WEST SUSSEX COUNTY COUNCIL CONSULTATION

TO:	Arun District Council FAO: Hannah Kersley
FROM:	WSCC Highways - Public Rights of Way
DATE:	16 February 2026
LOCATION:	Phase 6a Hampton Park Littlehampton
SUBJECT:	LU/249/25/RES Approval of reserved matters following LU/47/11/ (amended by LU/182/15) comprising 288 No residential dwellings, the formation SUDs features, children's play space, landscaping, car parking, roads, landscaping and public access to the northern extent of the Black Ditch Open Space.
DATE OF SITE VISIT:	n/a
RELEVANT PUBLIC RIGHTS OF WAY NUMBER(S):	Footpath 3096
RECOMMENDATION:	Objection
S106 CONTRIBUTION TOTAL:	n/a

scheme: Hampton Park Littlehampton
client: Persimmon Thames Valley
drawing: POS North Black Ditch
date: November 2025
scale: 1:200@A1
drawing no: PERTV24807 19 - Sheet 2 of 16
drawn: JO checked: RH

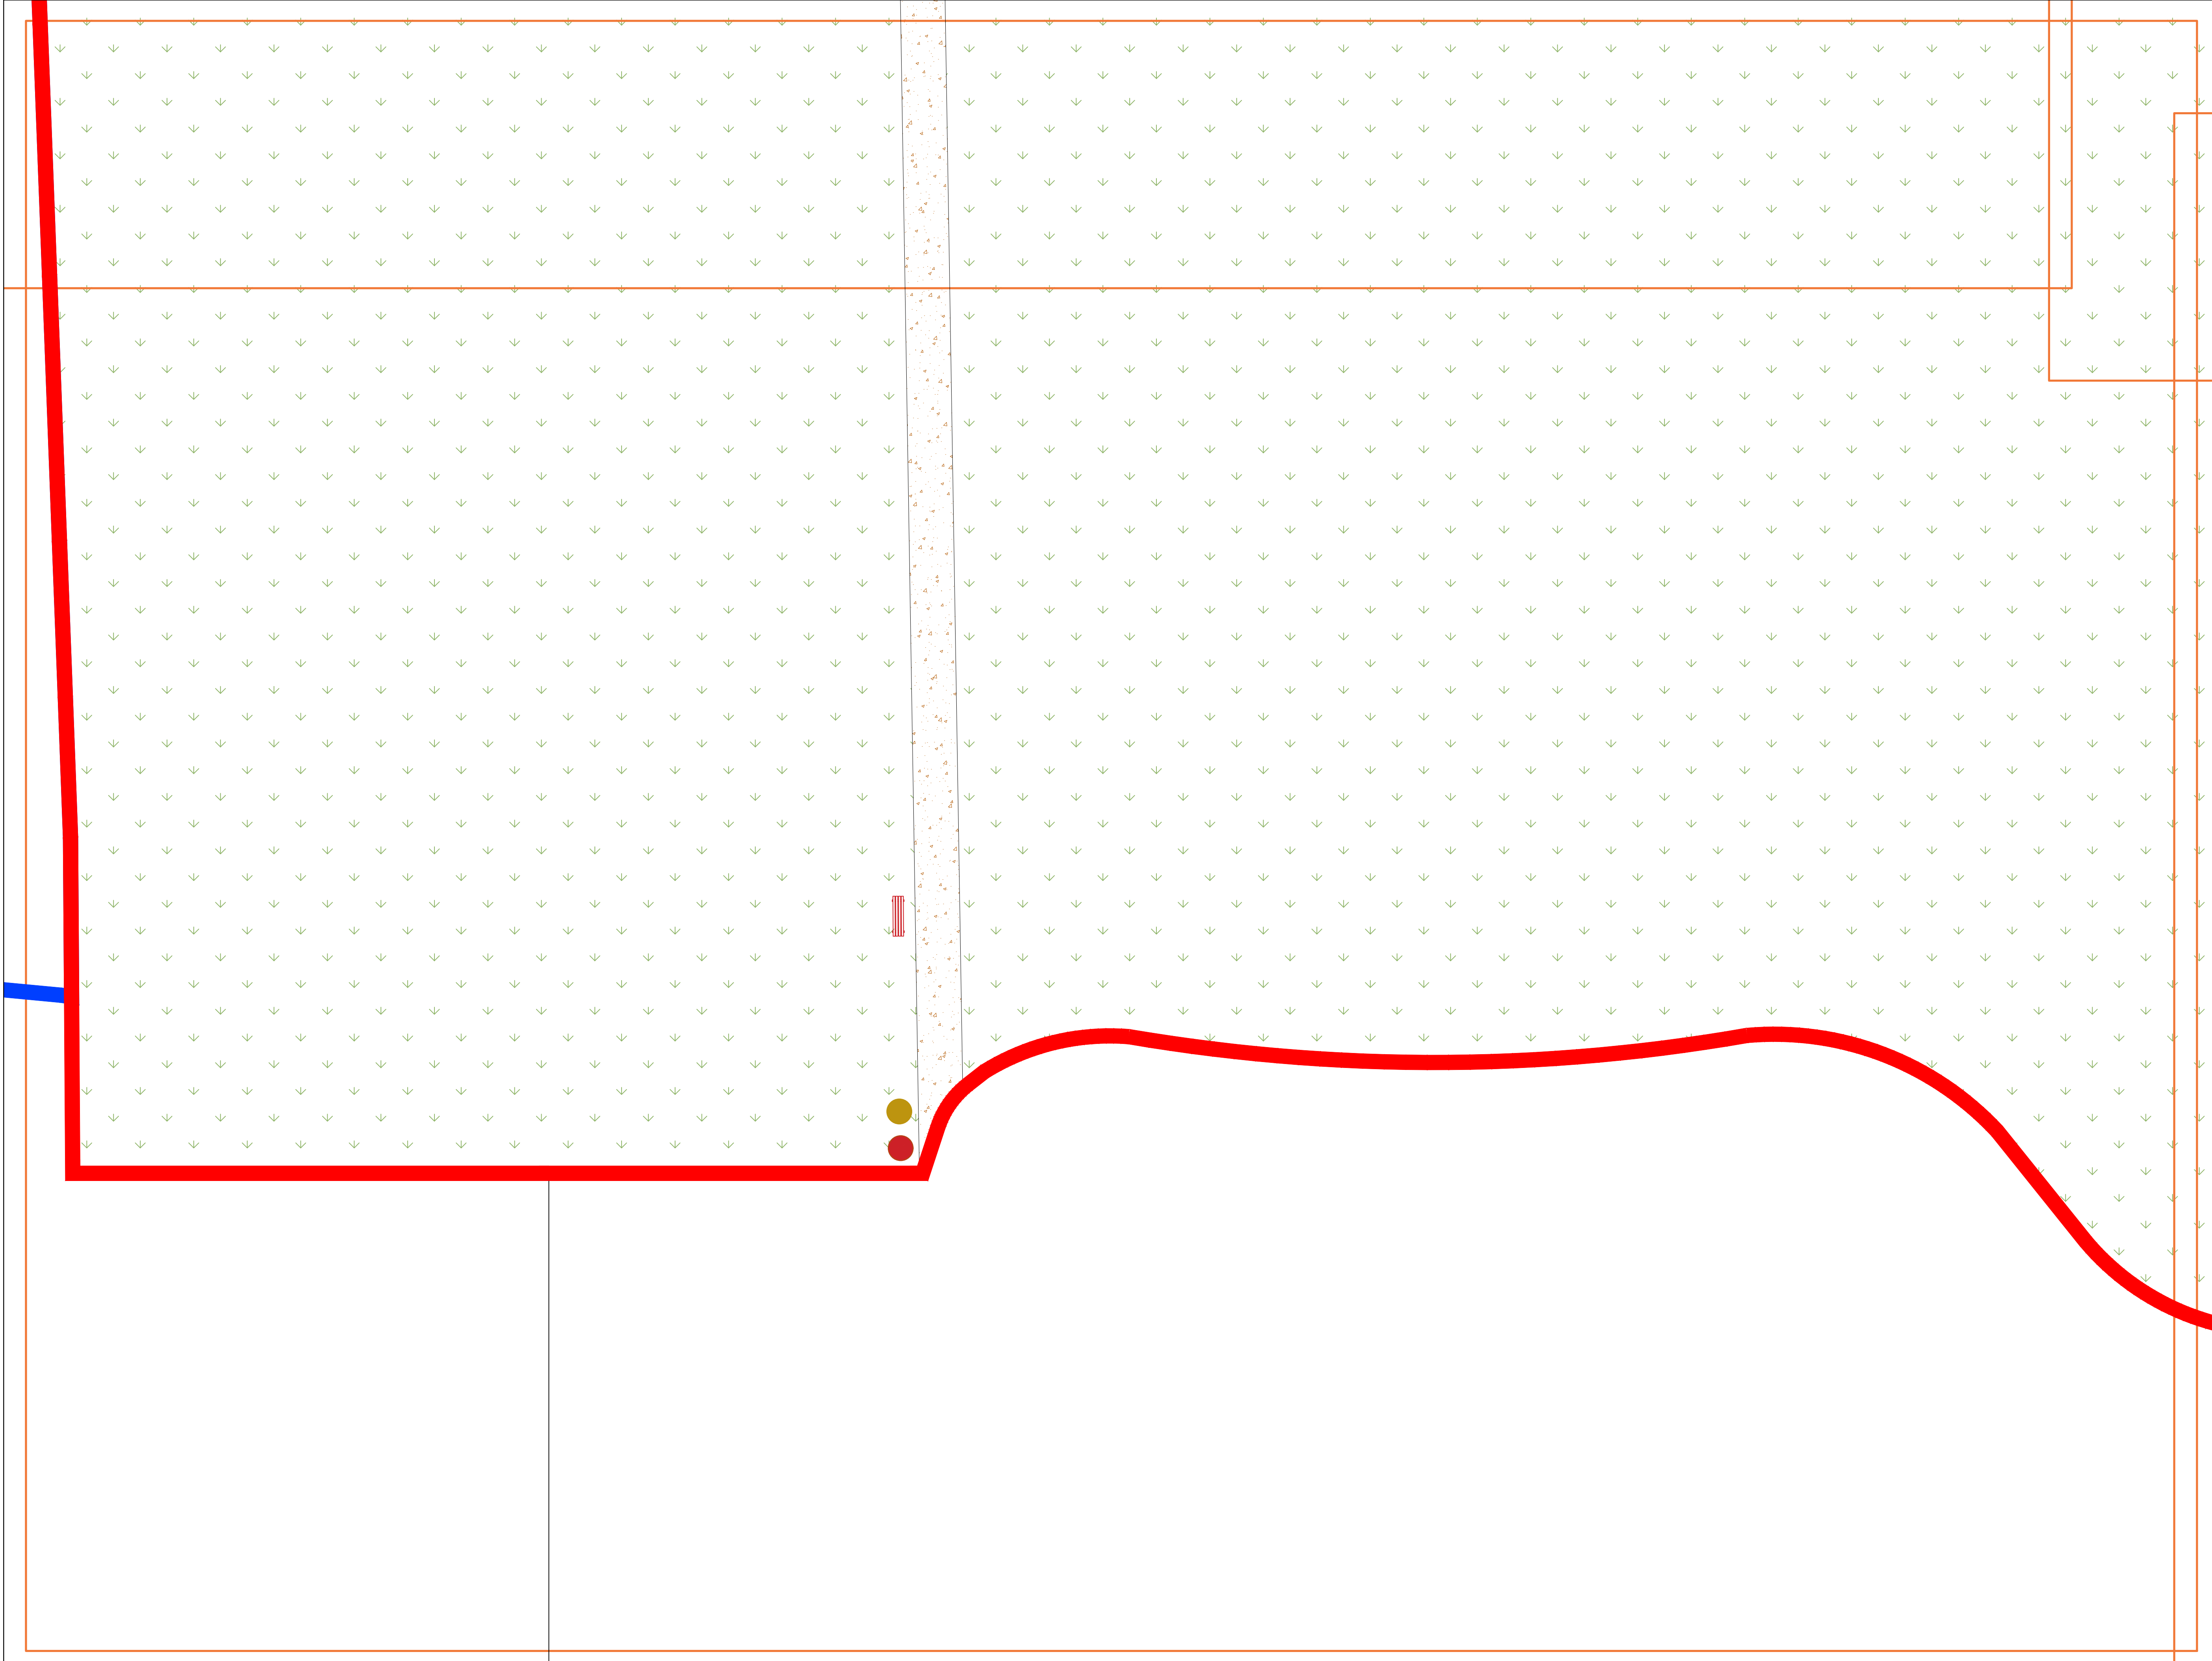
Plans show that the section of Footpath (FP)3096 within this reserved matters application area is to be a shared cycle / pedestrian use path and constructed as a crushed limestone path with gridforce ground reinforcement. My objection is made on both these grounds.

Given there is no continuity for cyclists at the northern end of the path within this area, the path should remain for pedestrian use only. Cyclists approaching this section of the Footpath from the development to the south will be able to go east or west but informed via signs that they should dismount at that point if they wish to continue northwards.

The surface should therefore be made up to the specification for pedestrians which we are able to maintain given that we are responsible for it, and in line with our rural footpath specification, shown below.

OPTION A	
<i>Sub-base</i>	
Clean material suitable for use as a sub-base with grading approximately 75mm to dust (e.g. crushed chalk or similar quarried stone)	175-225
<i>Surface / Top Dressing</i>	
Type 1 Limestone	100
Limestone Dust	25
